Please ask for: Nicola Moore
Email: nicola.moore@arun.gov.uk
Telephone: Ext 37944
Our Ref: LU/276/20/HH
Your Ref:
Date: 2nd November 2020

Application for Planning Permission for Works or Extension to a Dwelling

Development: Side Extension and 2 storey rear extension (Resubmission of previously approved LU/334/19/HH).
Location: Parkfield Worthing Road Littlehampton BN17 6SH

PROPOSED SOUTH ELEVATION

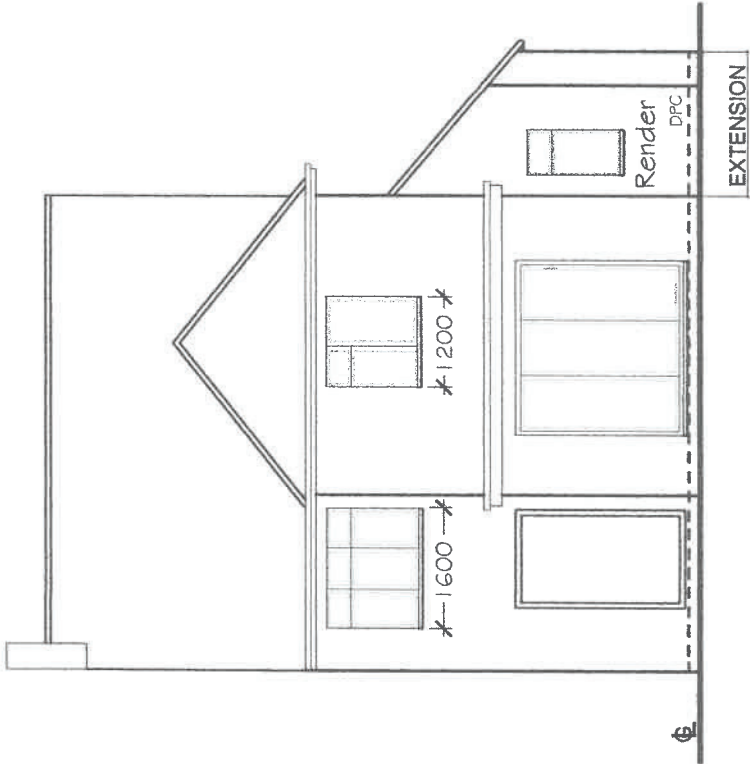
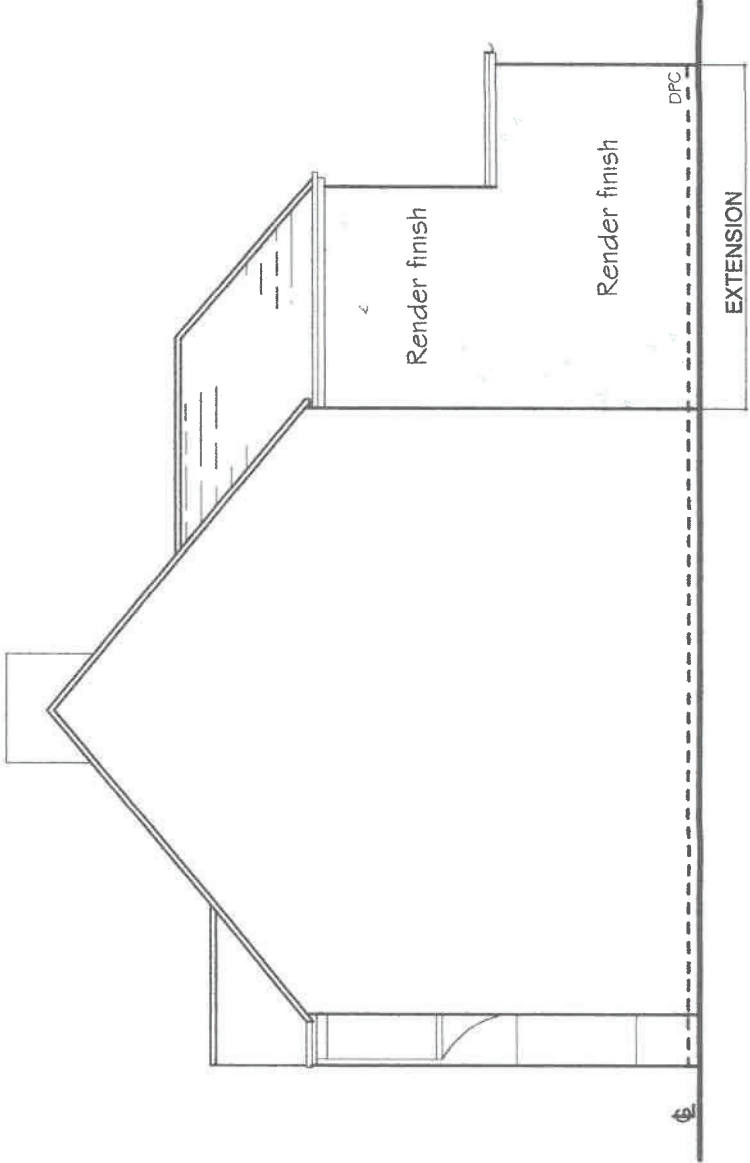
The first floor windows on the South Elevation measure 1.6m and 1.2m on drawing number 03 Proposed Elevations, and 1m and 1.2m on drawing number 04 Proposed Floor Plans. Please check the measurements, amend accordingly and resubmit.

DRAWING
BLOCK PLAN

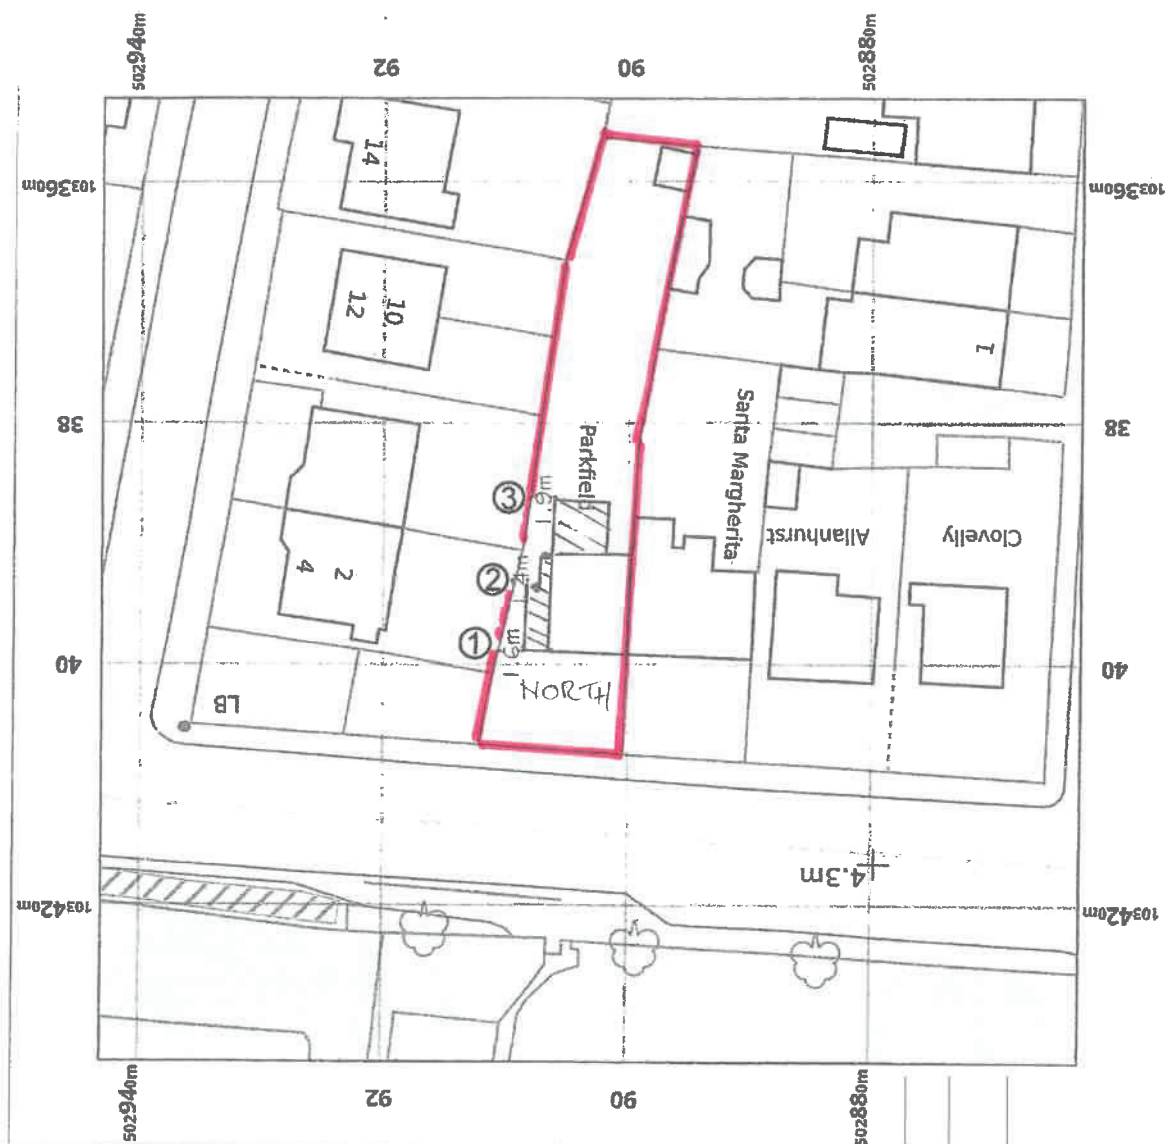
Block Plan

Please include written dimensions to boundaries and re submit.
